Application Reference: Y/70/22/DOC Site Name: Land at Blisham Road, Yapton	Initial Issue Date: 04/10/2022 Issue Date: 01/02/2024 Reviewer Reference:
---	---

Description of Works: Approval of details reserved by condition imposed under ref Y/91/17/OUT relating to Condition Nos 9 - surface water drainage and 27 - levels.

CLASS S PIPE BEDDING & SURROUND (NTS)
CLASS Z PIPE BEDDING & SURROUND (NTS)

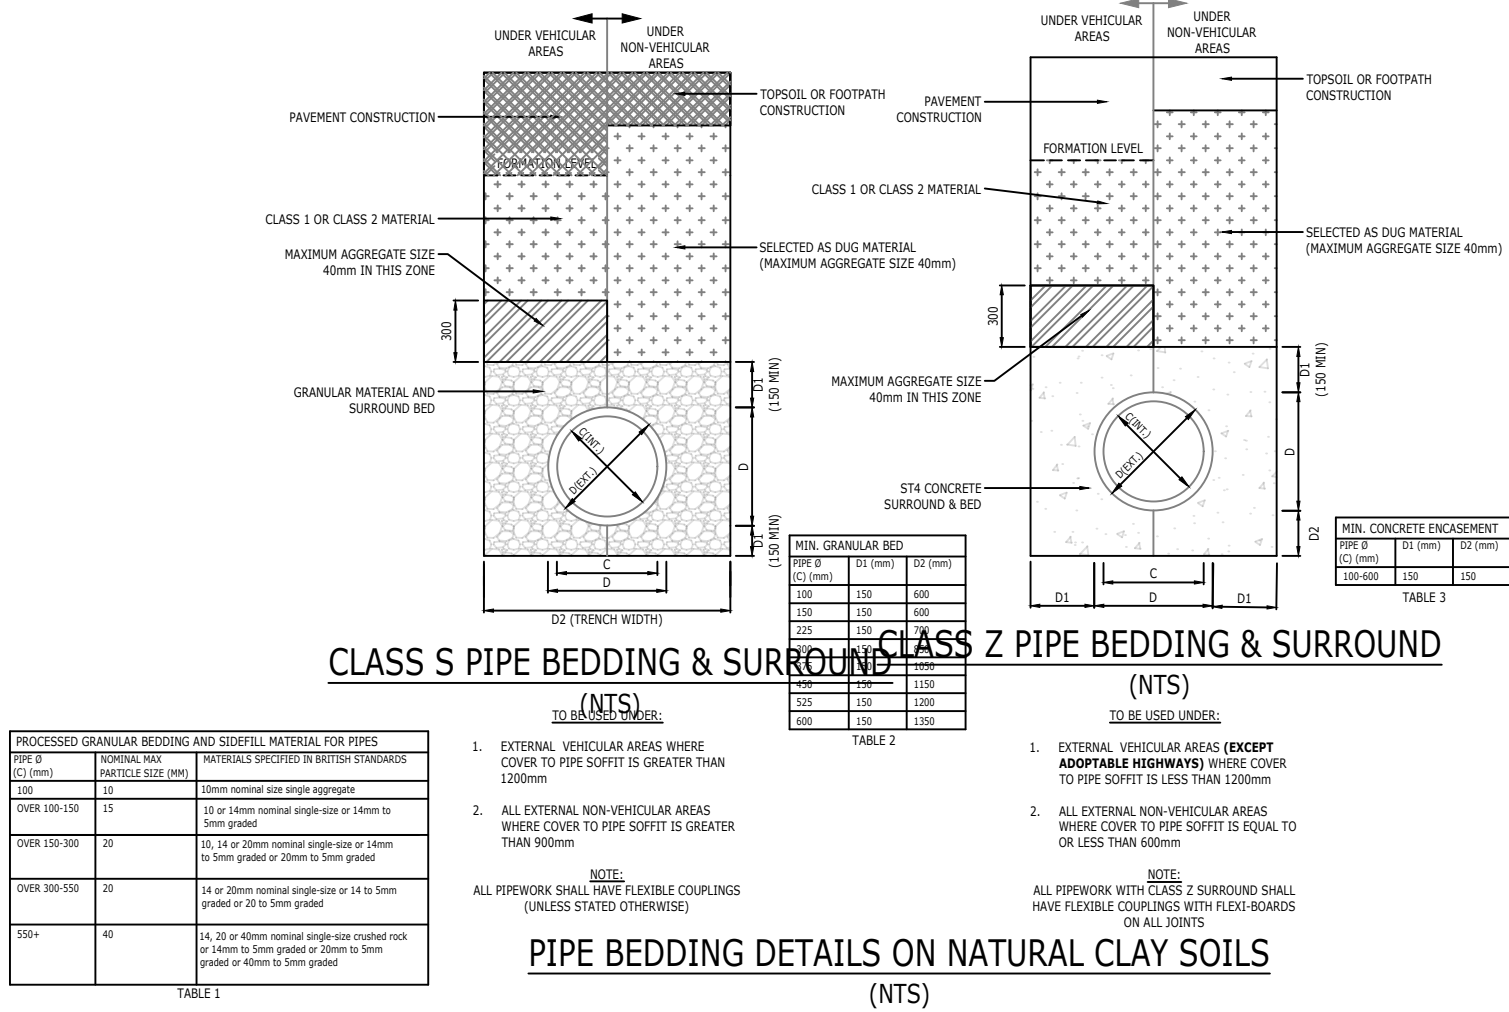
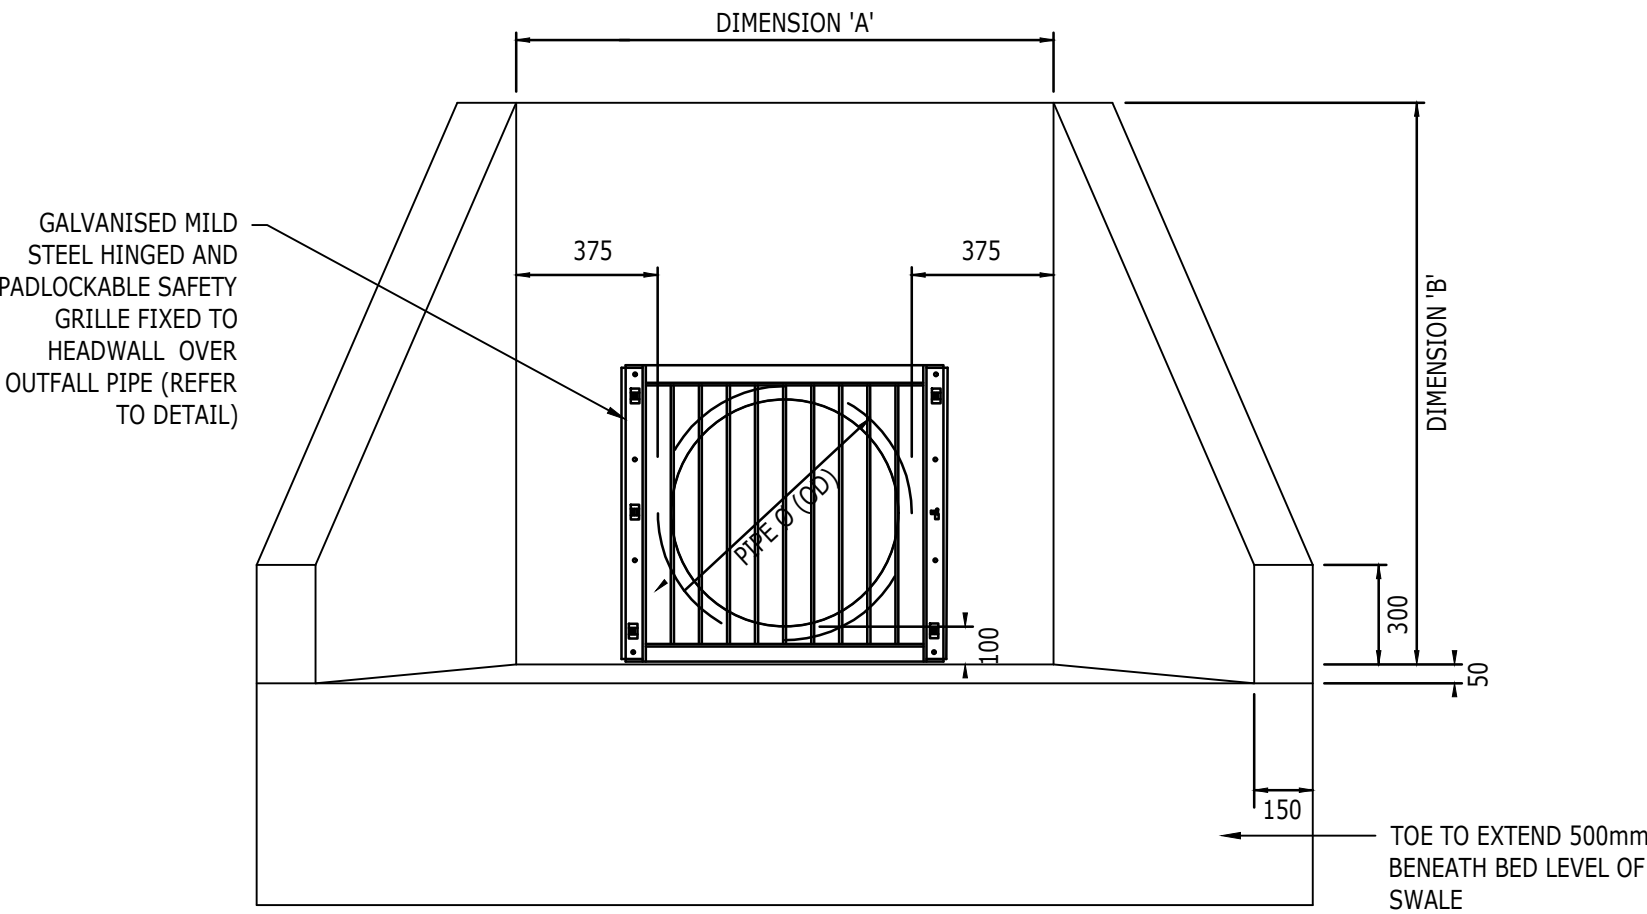
11.	Please provide cranked grilles at a 45 degree angle.	Cranked grilles required on heads – S104 Construction details sheet 1 of 2 D1956-15-100 needs to be updated to suit ADC requirement. Pipe beddings details on this drawing are illegible in parts. Information needs to be clearly presented. We note that applicant’s response that this is not “DSG compliant” however the drawings refer to Sewers for Adoption 7th Edition. As such the applicant needs to be clear which edition of Sewer for Adoption the adoptable drainage is being designed to. In addition they should confirm who the adopting authority will be as well as confirmation from the adopting authority on whether they will or will not accept cranked grilles. 08/02/2023- Whilst is noted that the Technical Approval certificate has been provided for information, this doesn’t clarify whether the adopting authority has	Accepted by the LPA as designers risk,– Now closed

considered a request to use cranked grilles. This needs to be confirmed by the adopting authority otherwise cranked grilles should be used. 09/07/2023 – We await your submission of the confirmation from the adopting authority or as previously advised this should be amended to meet the requirements of Arun District Council.
